Our ref: DOC19/110341

NOTICE OF EXHIBITION FOR REDEVELOPMENT OF GREENWICH HOSPITAL AT 97-115 RIVER ROAD, GREENWICH (SSD 8699)

As delegate of the Heritage Council of NSW, I provide the following comments:

DRAWING TITLE:  
SENIORS LIVING APARTMENTS - BASEMENT &  
PODIUM LEVELS  
DATE:  
FEB 2018  
DRAWN:  
Author  
PROJ:  
1213  
CHECKER:  
1:250@A1  
REVISION:  
T3

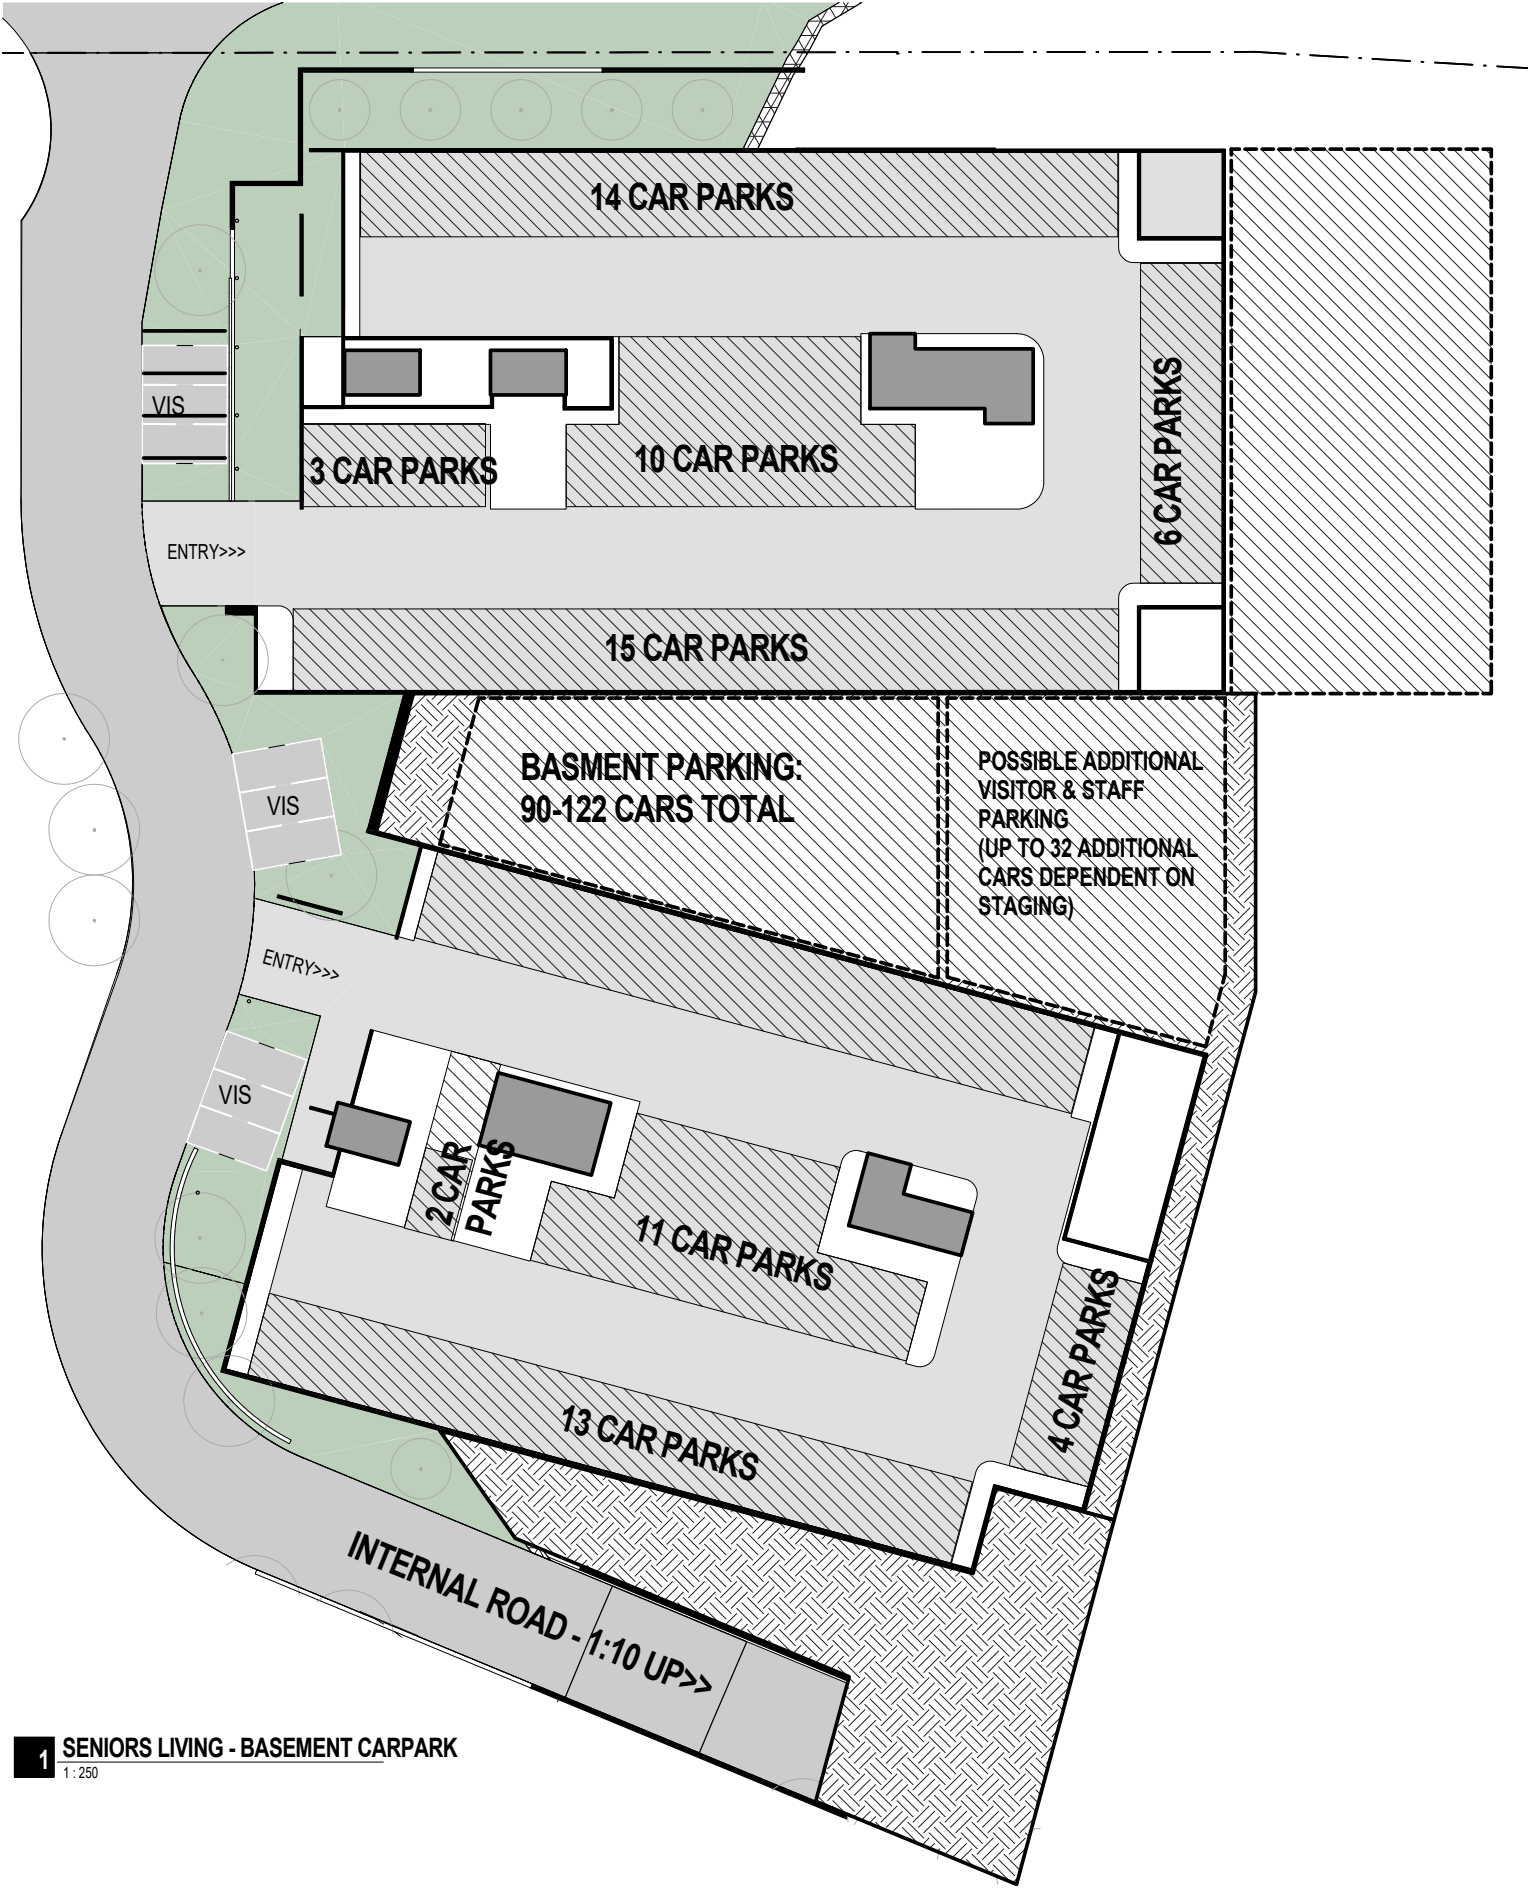
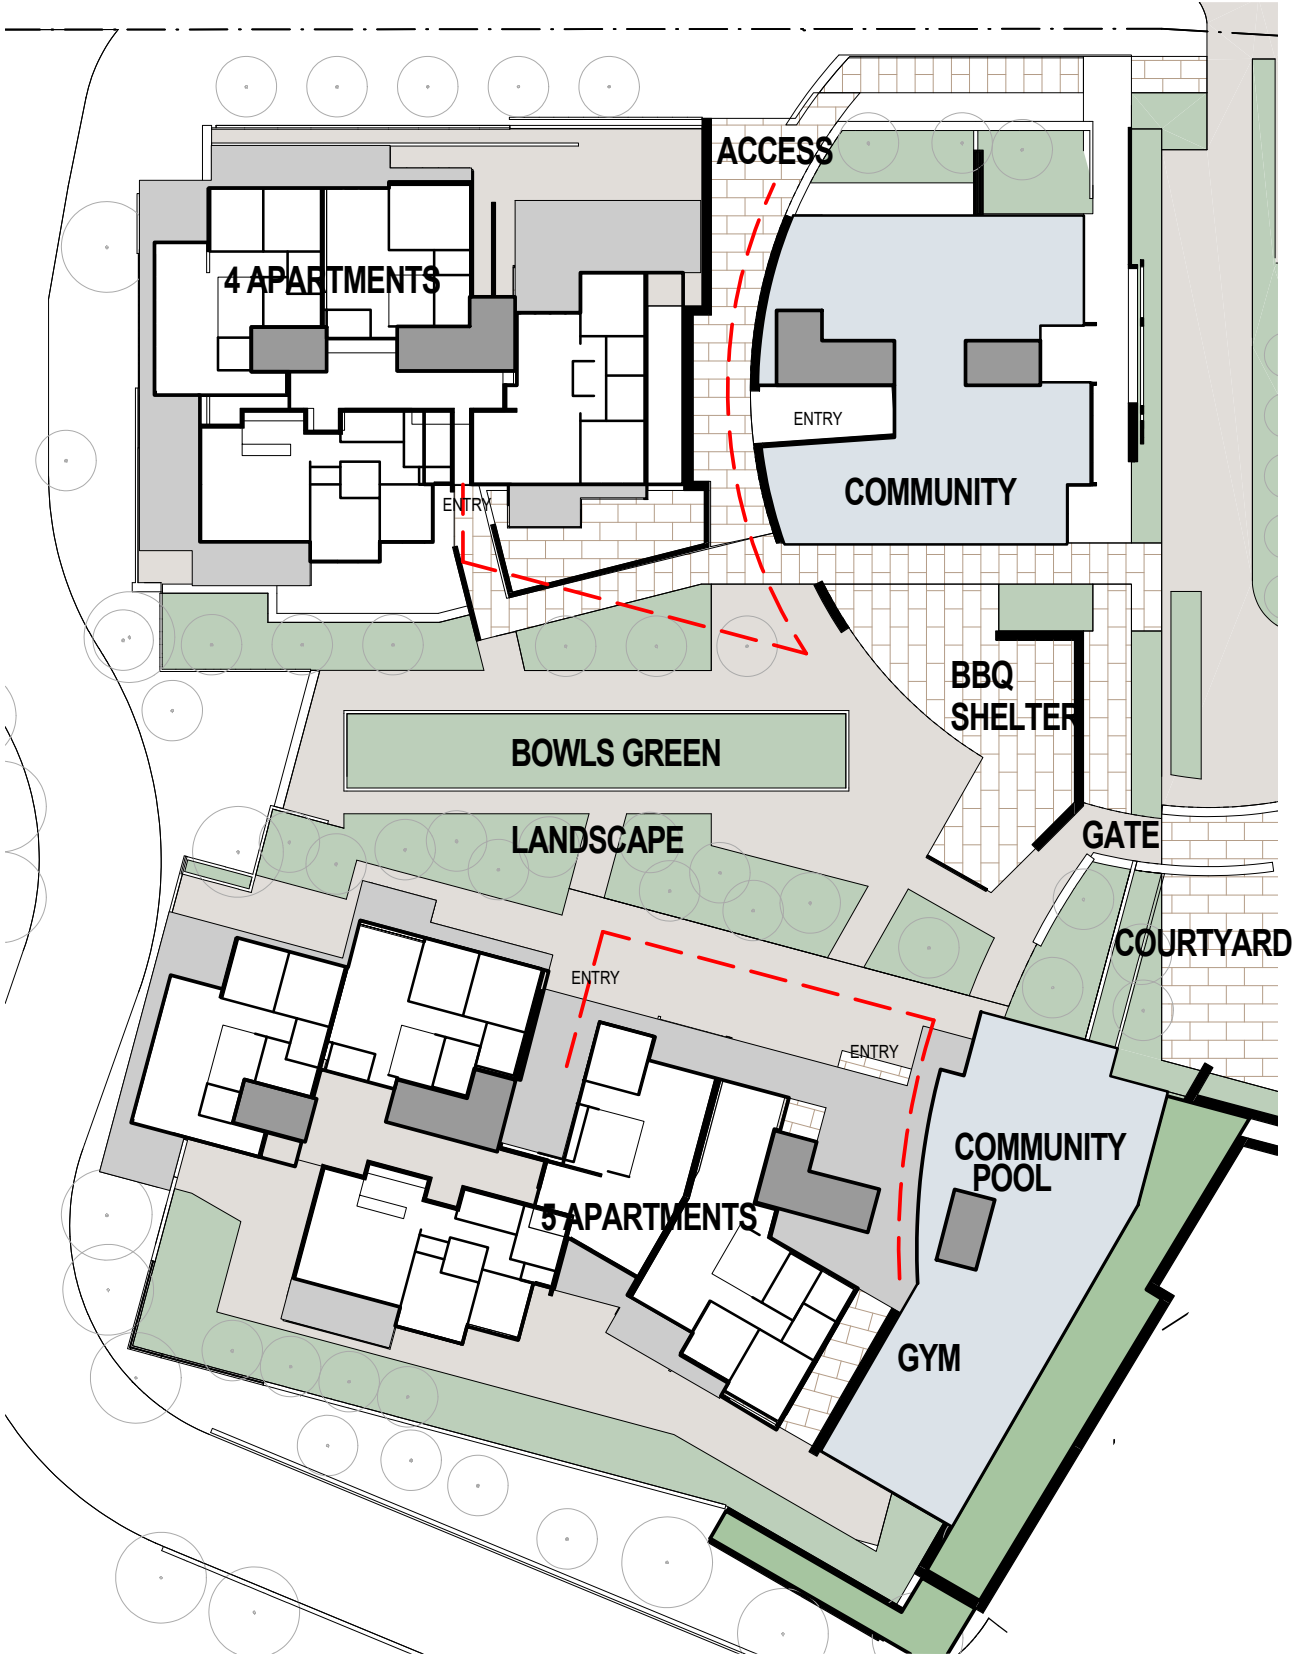
- The proposed basement car parking would encroach into the curtilage of Pallister. This could have an adverse impact on the structural integrity of the historic villa. To mitigate these impacts, the basement car parking should be moved outside the curtilage;

- The proposed basement car parking is to be modified to be wholly outside the curtilage of Pallister to mitigate any potential adverse impacts on the structural integrity of the historic villa.

DRAWING TITLE:  
**SENIORS LIVING - ST VINCENTS ROAD VILLAS**  
DATE: FEBRUARY 2018  
DRAWN: 1213  
PROJ ARCH: S.V.01  
SCALE: 1 : 250 @ A1  
REVISION: T3

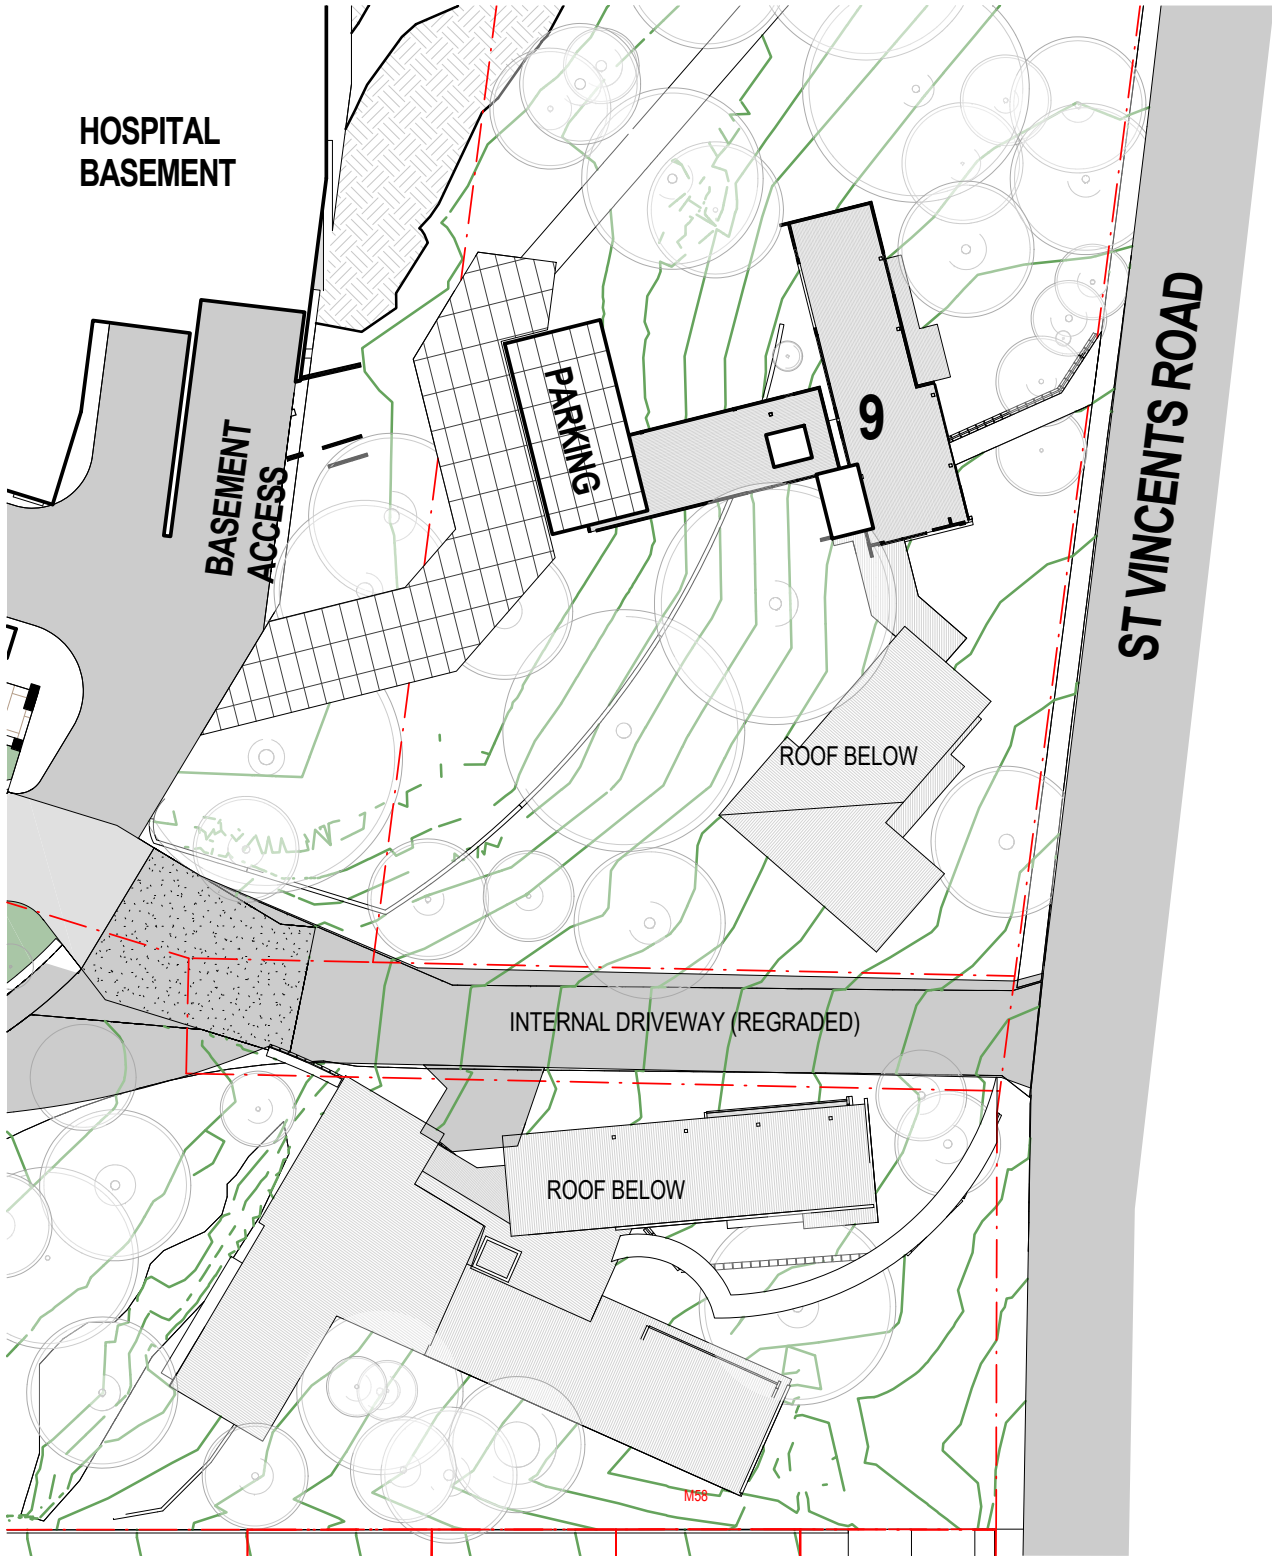
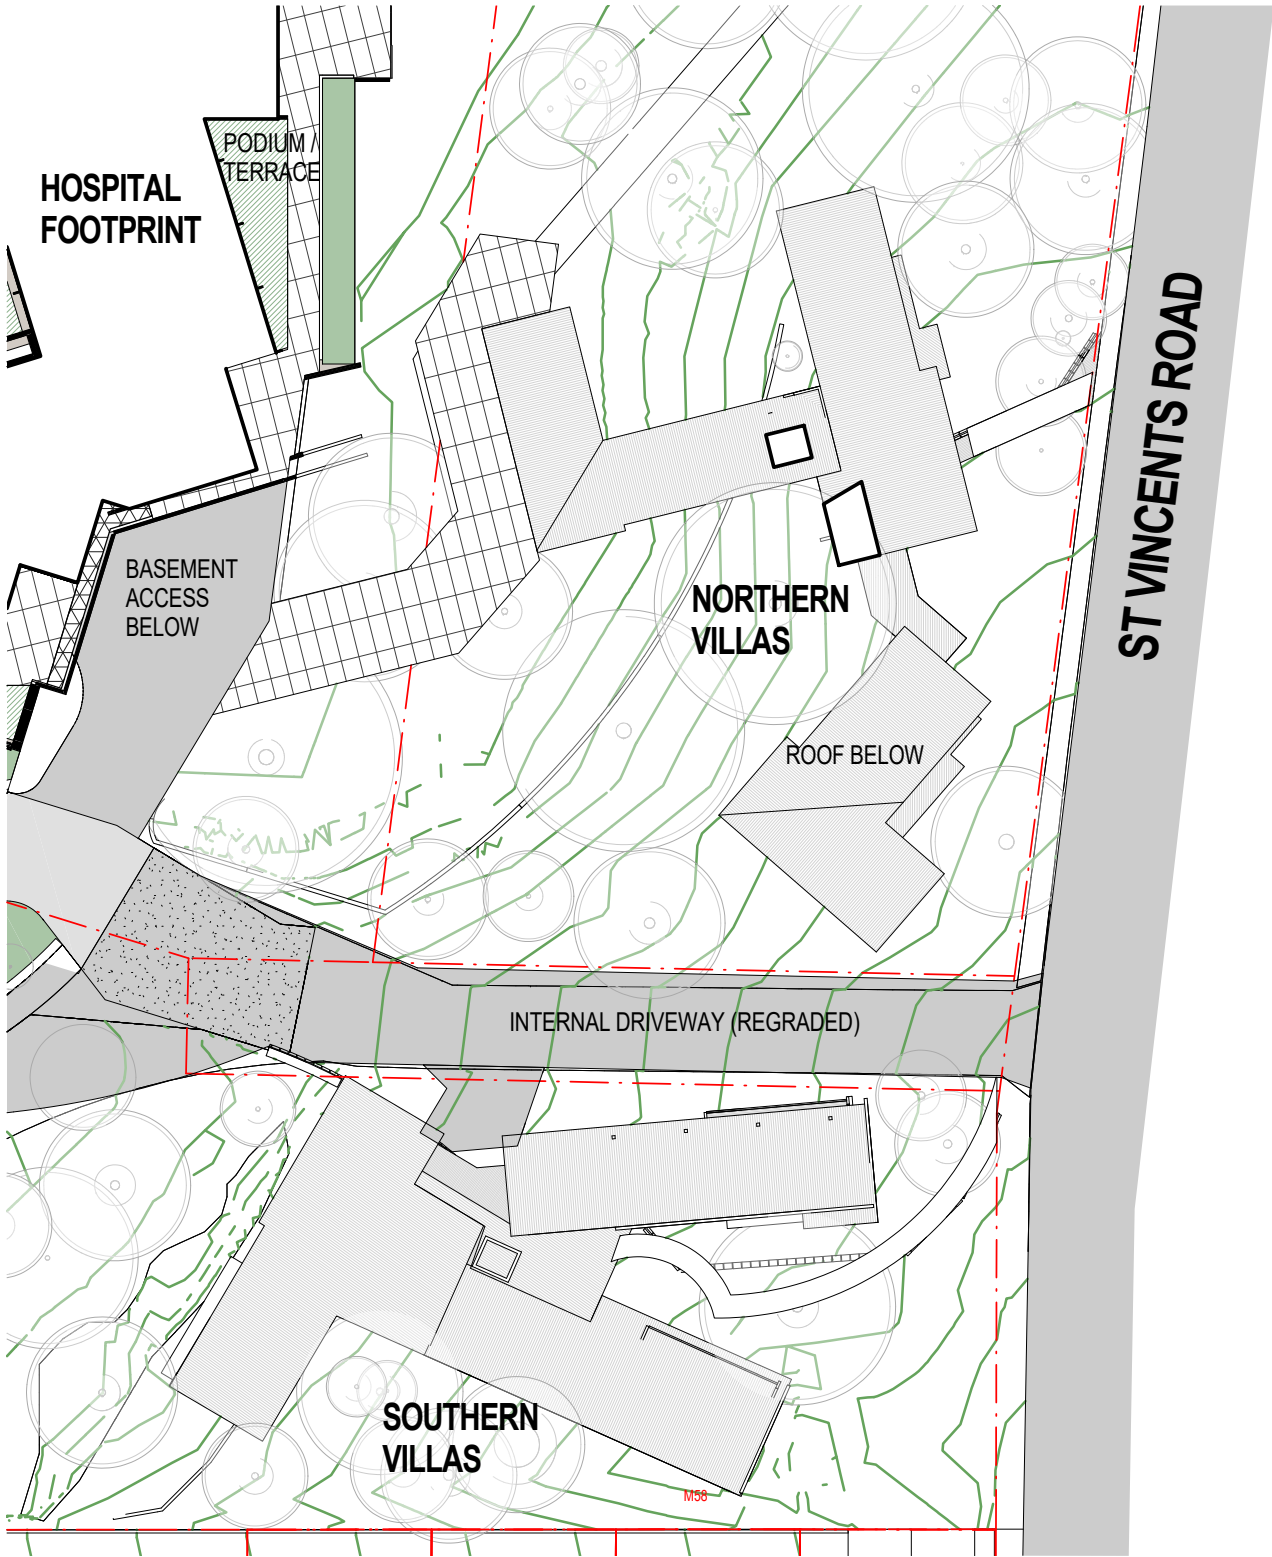
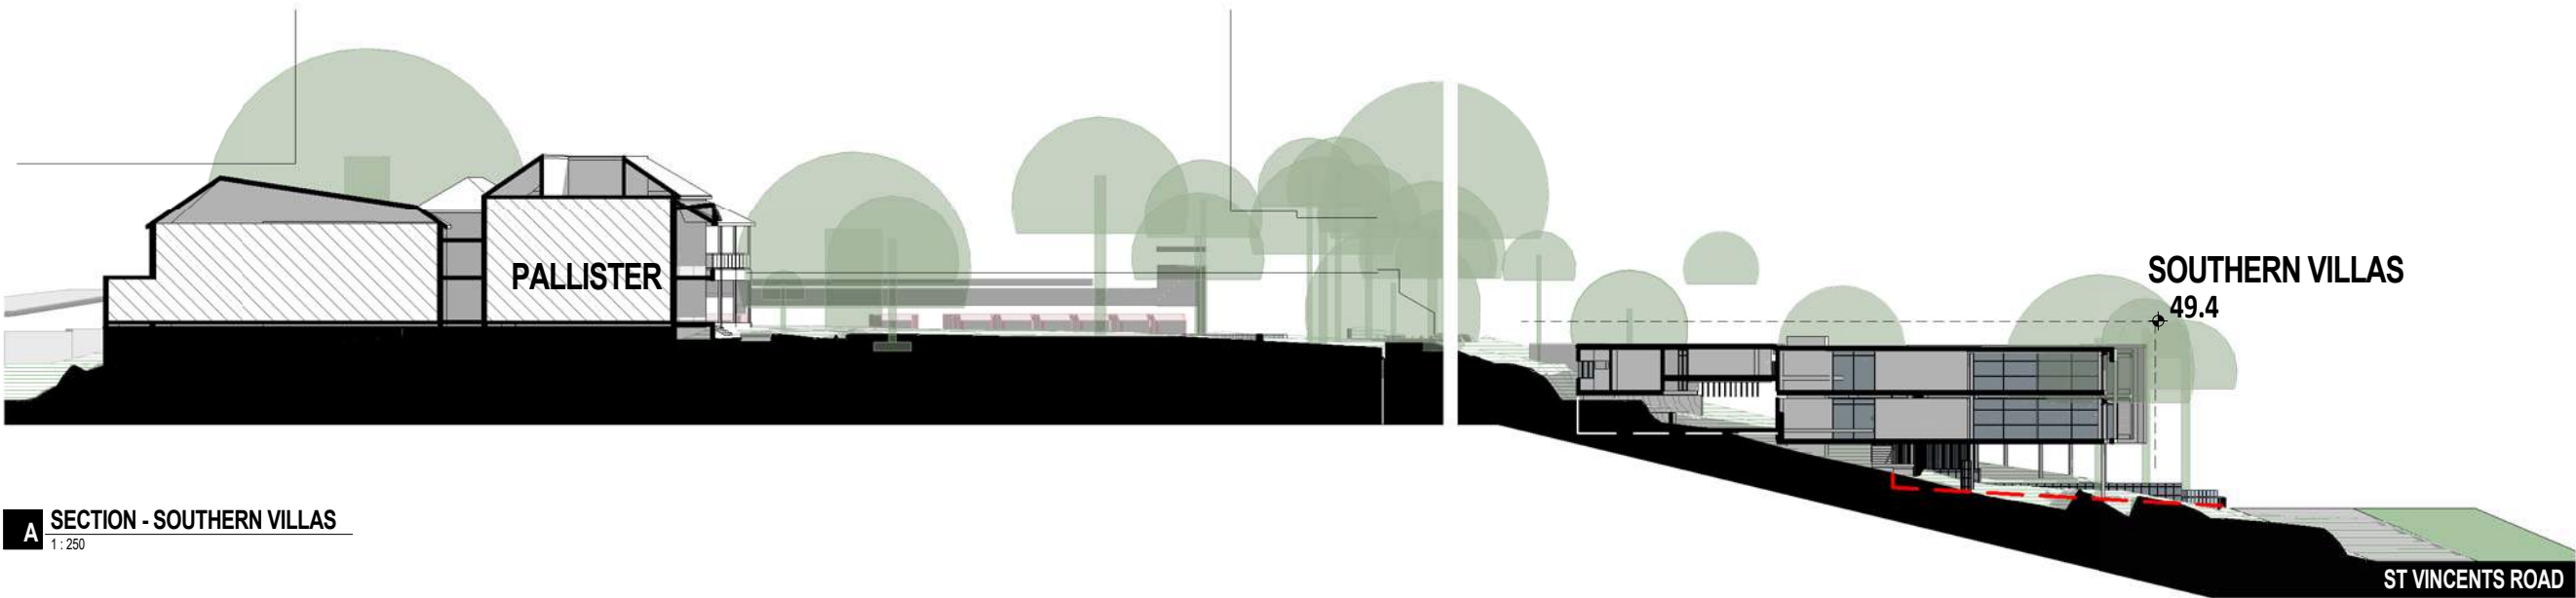
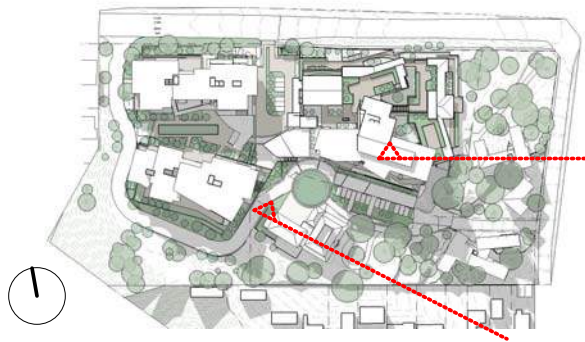
- The removal of a large amount of mature vegetation which contributes to the setting of Pallister would adversely impact the significance of the heritage item. By removing the southern seniors living villas, many trees within the curtilage could be retained, positively impacting the future setting of Pallister;

- **Modified Concept Proposal:**
 - The concept proposal is to be modified to remove the seniors living villas proposed to the south of the St Vincents Road access drive. Any seniors living villas within the curtilage are to be to the north of this access drive only. This modification would help retain the connection between Pallister and St Vincents Road, the landscaped setting of the historic villa, and reduce the visual impacts on the State significant heritage item.
